Zac Denton
Planning Dept
Arun District Council
Arun Civic Centre
Maltravers Road
Littlehampton
West Sussex
BN17 5LF

19th July 2018

**Erection of 2 hipped dormers to front elevation replacing the existing velux windows.
Rear first floor hip to gable extension.
14 Windmill Drive, Rustington. Ref R/118/18/HH**

REAR ELEVATION
South

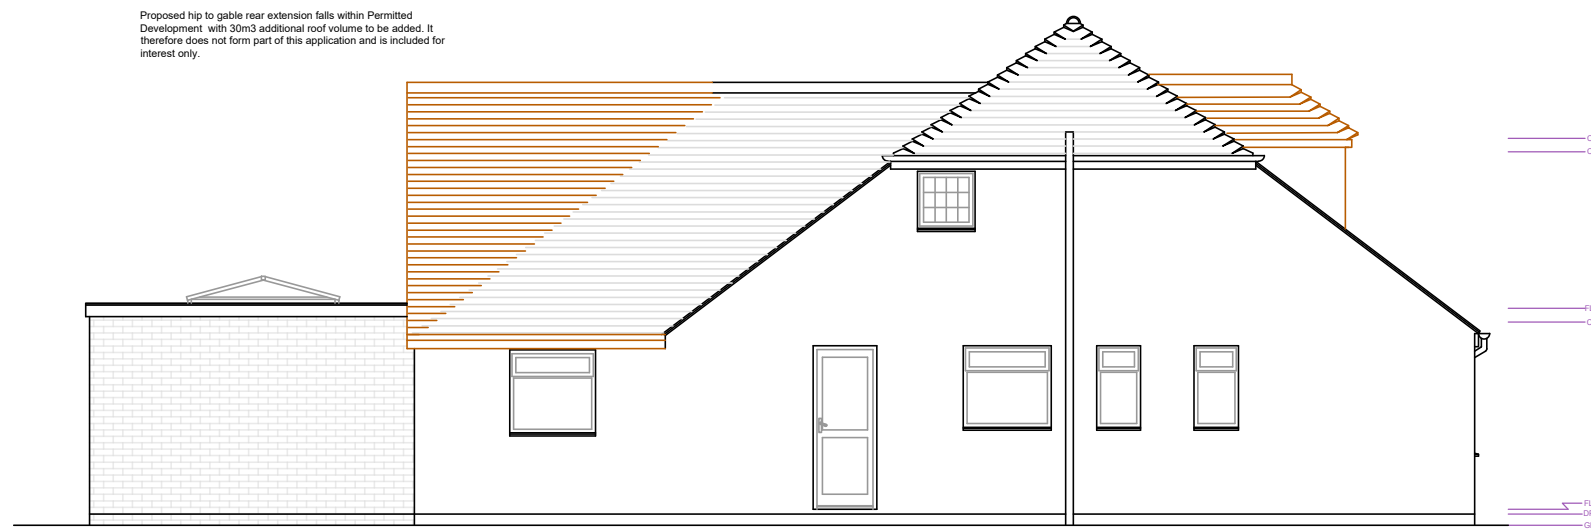
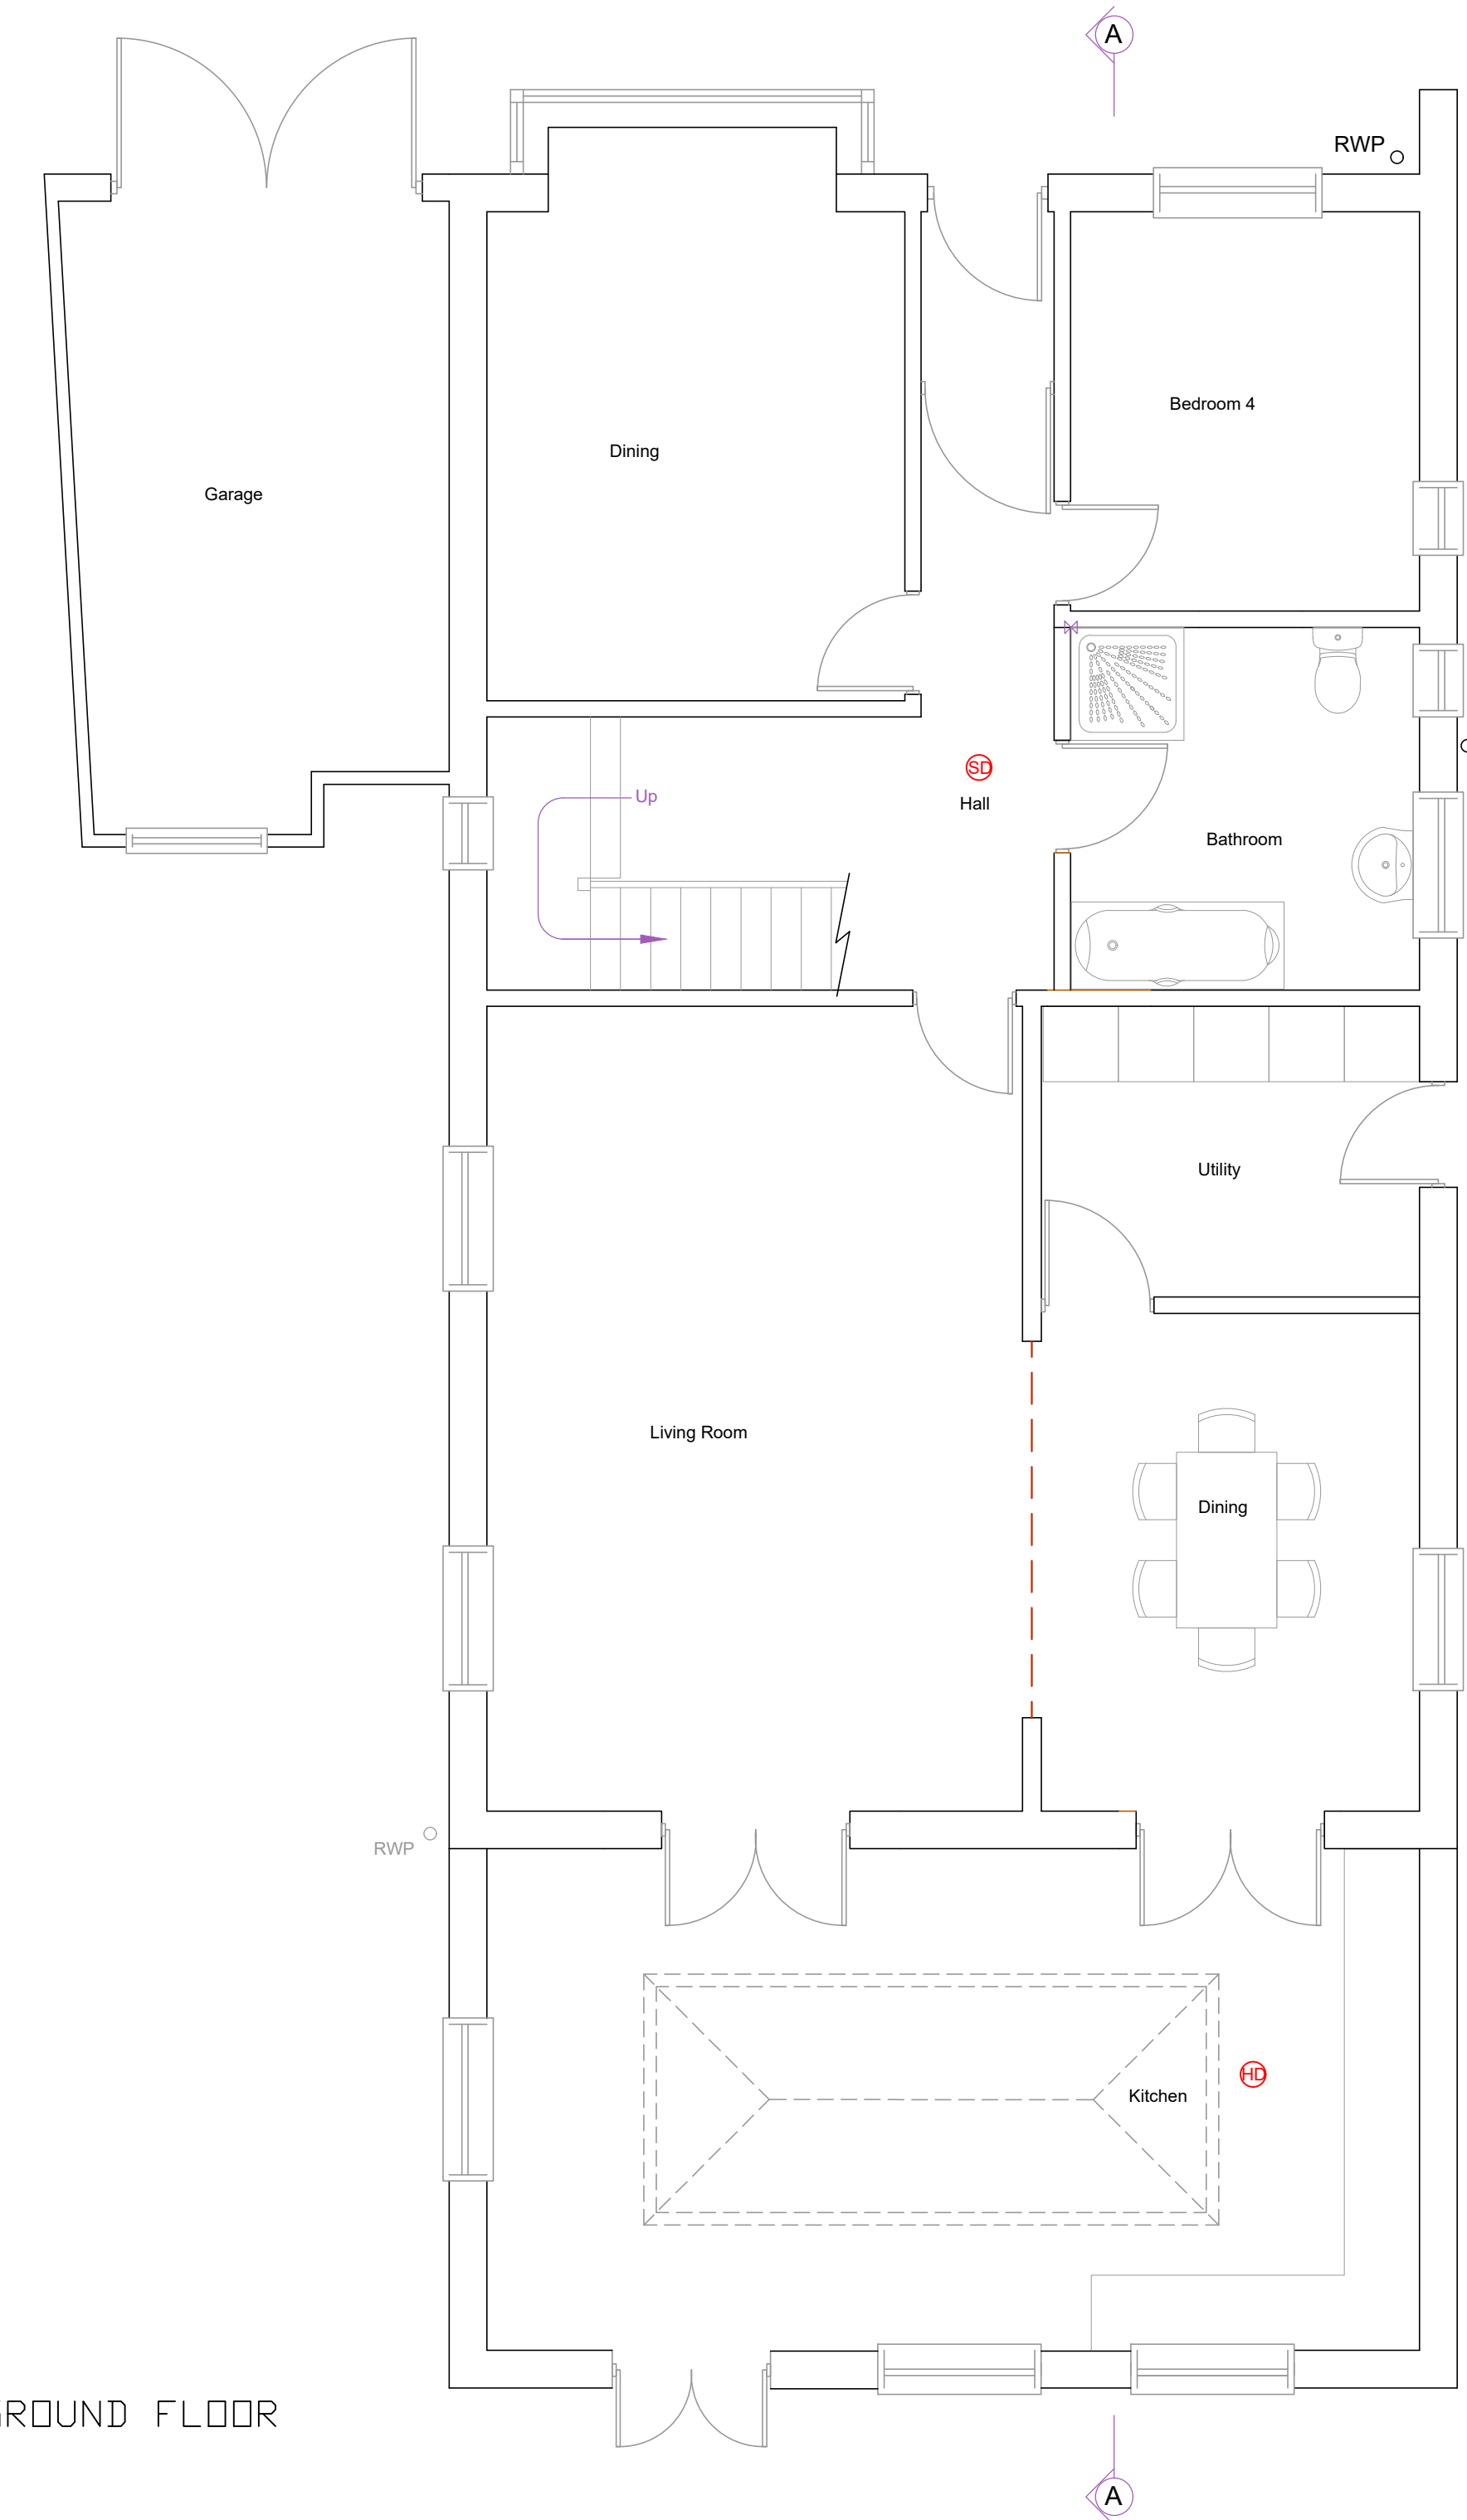
Firstly, I can confirm that my client has no objection to the front Dormers. They do however strongly object to the proposed rear first floor hip to gable extension. This was previously marked as permitted development, but is now included in the application.

With regard to the more recent proposal, under ref R/118/18HH, I hope that you will consider that the property has already been over developed with the two previous substantial extensions to the rear, and that a further rear extension would be a step too far. I fail to see how this first floor roof extension could possibly be permitted development as it is over the top of an existing extension which previously required planning permission (R/61/00) and is not over the footprint of the original building. See condition B2b(ii) highlighted in red below :-

1. The property has already been over developed with two previous large rear extensions. The footprint of the original property has been increased from 9.5m to nearly 18m.
2. The extension would over bear and over shadow the adjoining property.
3. The extension would be intrusive and detract from the enjoyment of the adjoining property and garden.
